# State Significant Development Response to Submissions

## Site 9, Sydney Olympic Park

### Mixed use Development

Submitted to Department of Planning and Environment  
On Behalf of Ecove Group Pty Ltd

**General Arrangement Plan  
Ground**

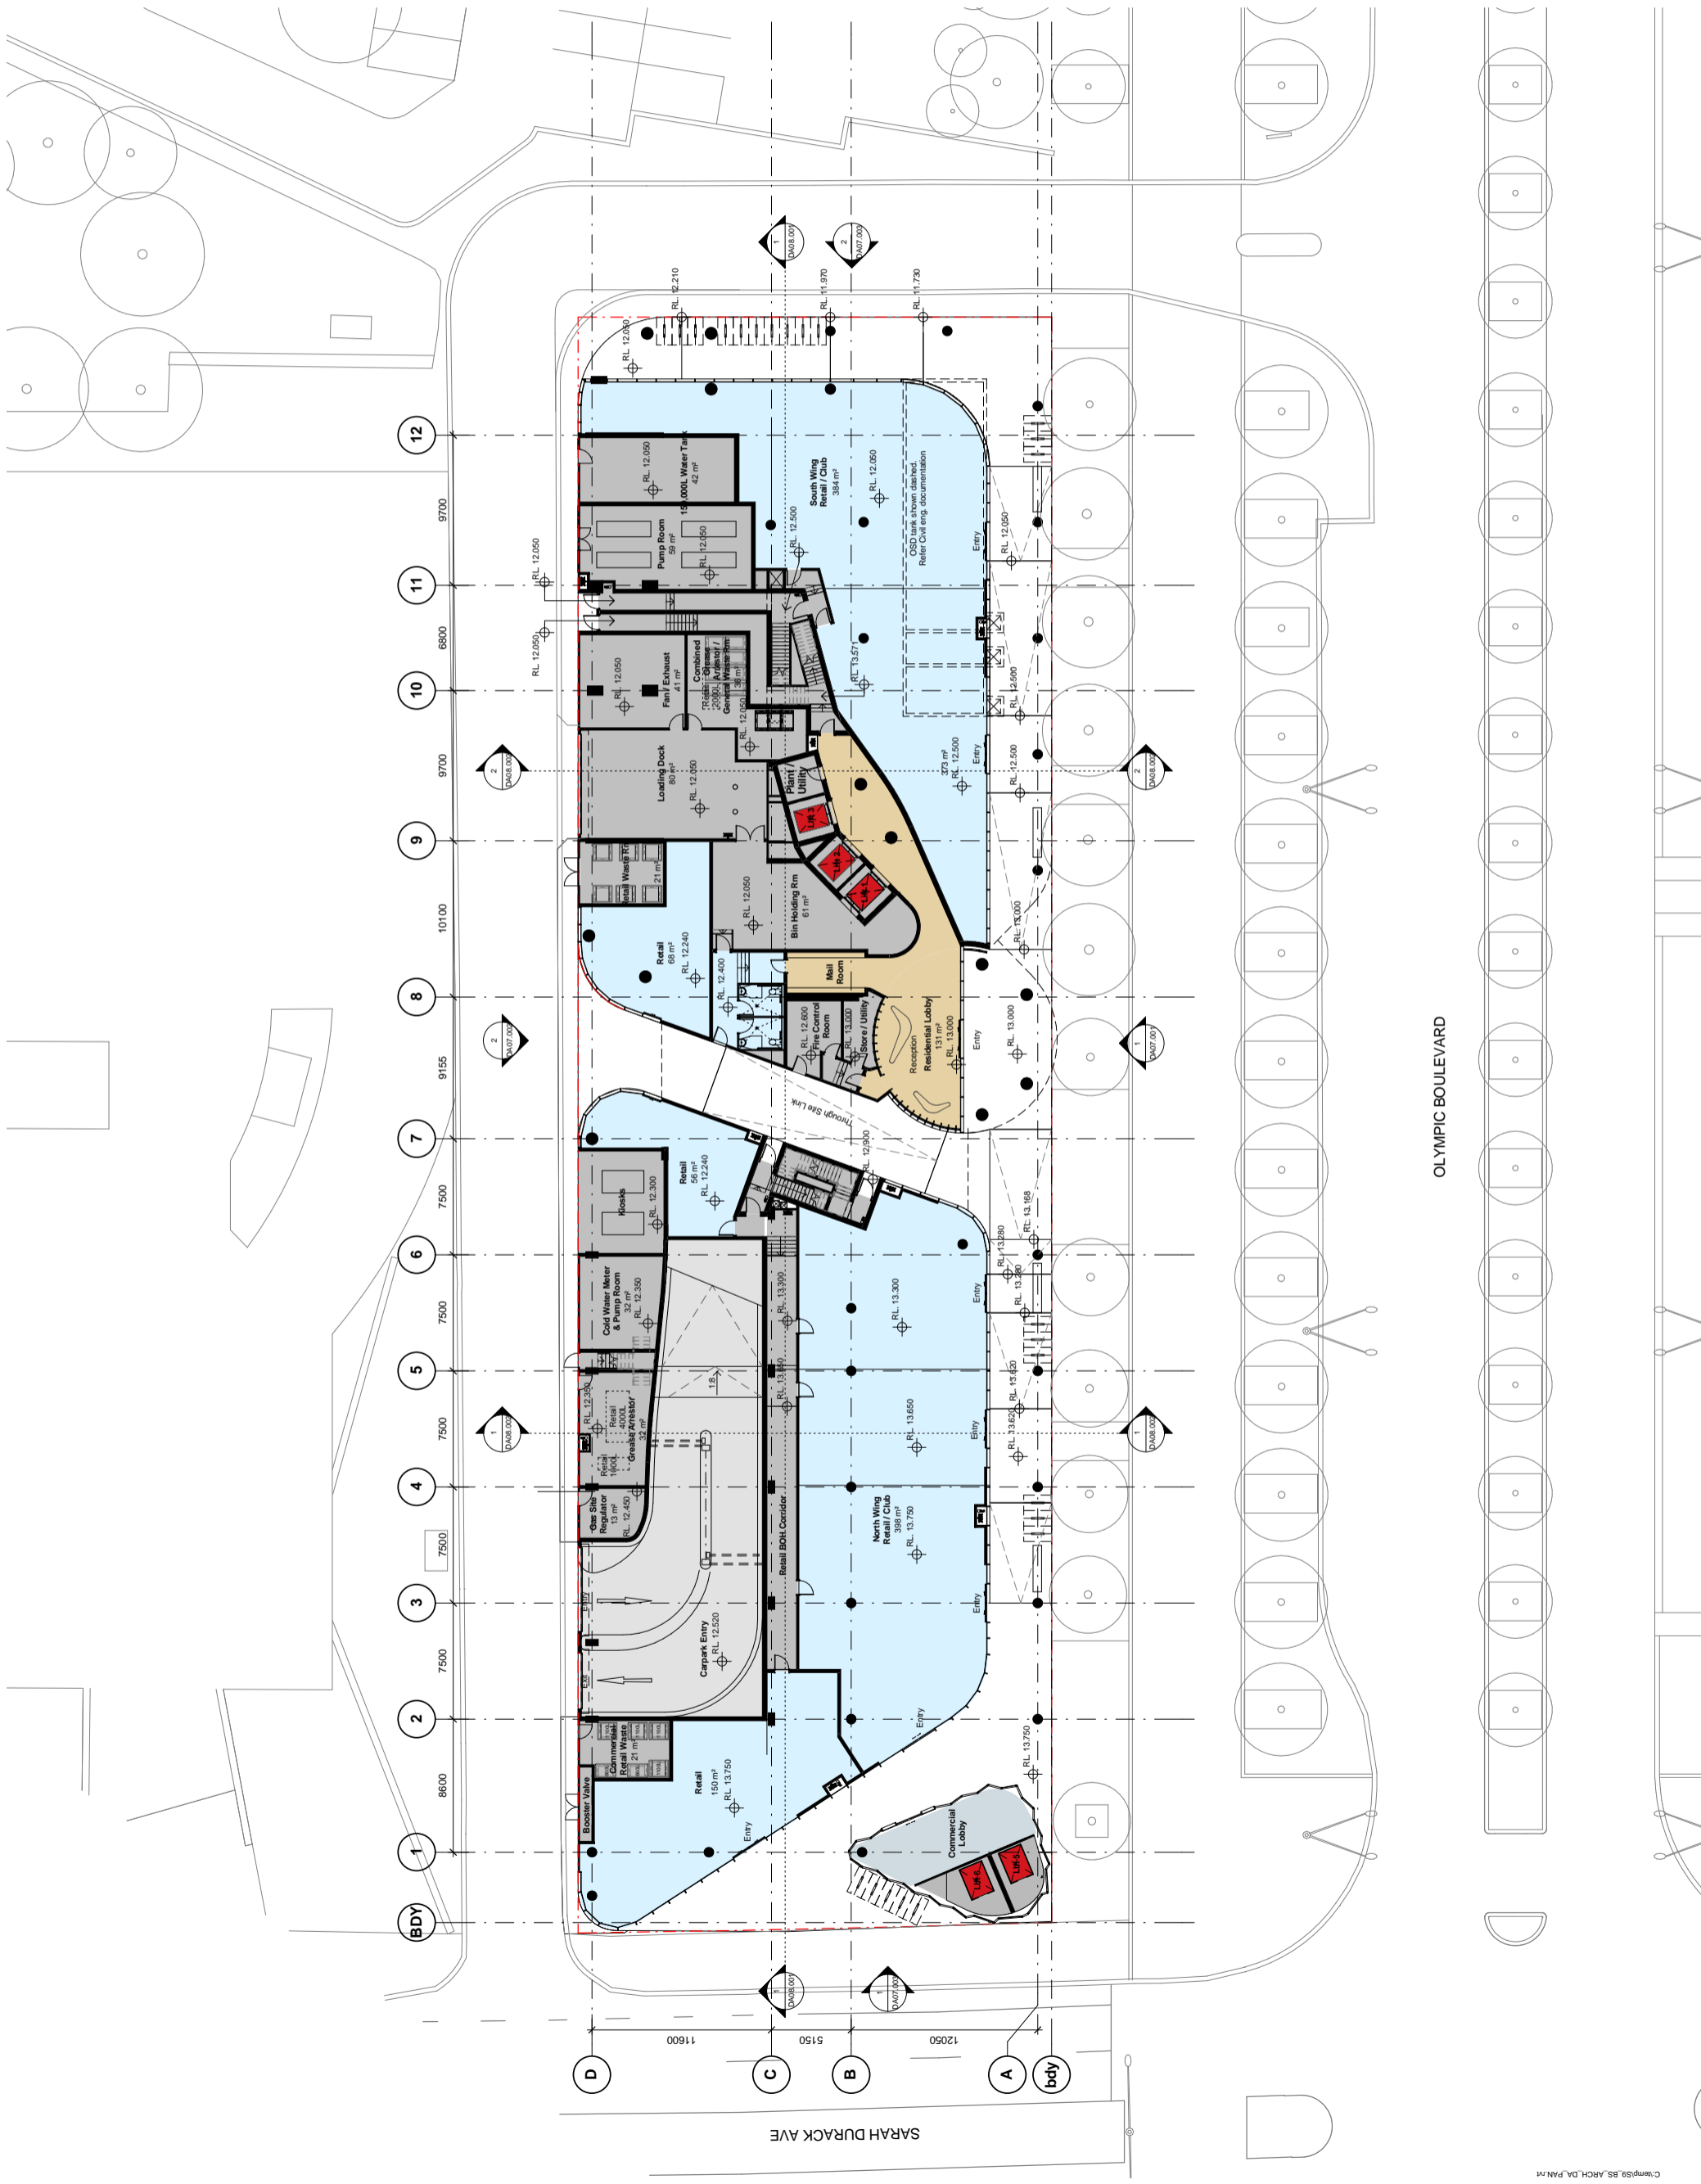
The proposed increase in the Ground Floor floor to ceiling height to improve the proportions of the colonnade also results in an increased height for the through site link. The proposed width of the link has also been reviewed, and it is noted that the 5.4m proposed exceeds the width of 4.5m recommended by the Site 9 Development Guidelines. The proposed width will permit clear pedestrian thoroughfare, and it is noted that casual bicycle parking has been relocated out of the link. An indicative montage of the link, illustrating the proposed proportions, is provided at **Figure 5**.

Further to these measures, the design of the through site link and adjoining building has been refined to further increase activation (refer **Figure 6**). Additional retail / commercial tenancies are provided at the eastern corners of the site link, which will provide additional activation to the link. The bicycle storage and plant have been relocated. (The bicycle storage will be relocated to Level 9 of the tower, requiring the deletion of one apartment on this level).
